**CITY OF PORTLAND**  
**Planning and Urban Development Department**

**MEMORANDUM**

**SUBJECT:** Temporary Certificate of Occupancy for 56 Shepherd Lane

I have reviewed the single family residence at 56 Shepherd Lane and believe it would be acceptable to issue a temporary Certificate of Occupancy. A permanent Certificate of Occupancy should not be issued until the following conditions have been met.

SITE PLAN 1
 LOT 5 ORCHAR
 SCD SHEPHERD
 KASPRZAK, INC.
 P.O. BOX 26, N. WI
 11/19/95 SCALE

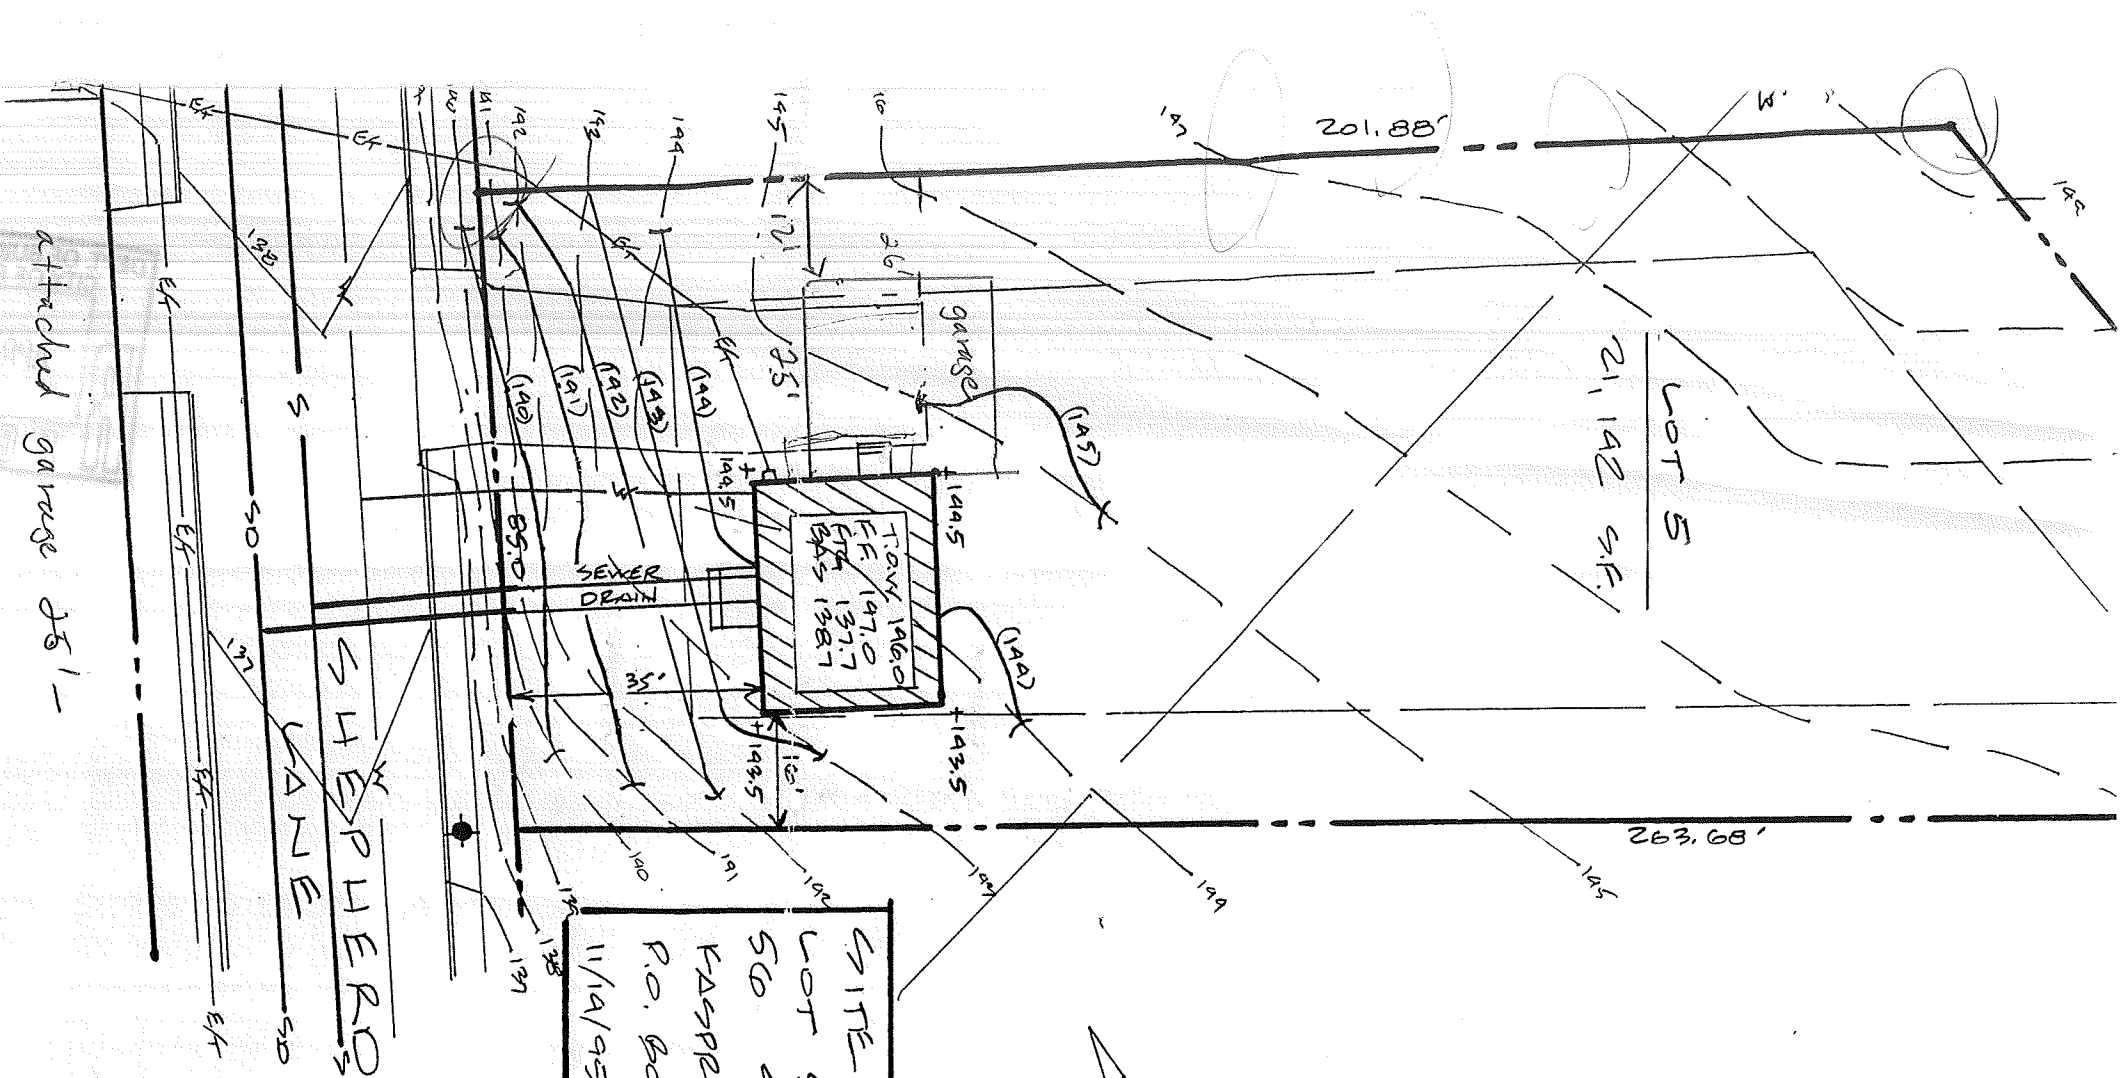
3. Silt fencing shall be installed immediately along the lot frontage behind the sidewalk to prevent sediments from collecting in the sidewalk on street. Also silt fence shall be installed along the southern property line. Silt fence shall be installed in accordance with the condition placed on the Building Permit Application dated 11/20/95. (Note 16 on the conditions sheet for the Site Plan Review.)

4. The rear of the lot shall be graded such that a swale will direct runoff away from the foundation and bulkhead areas and towards a proposed swale along the southern property line and eventually towards the street.
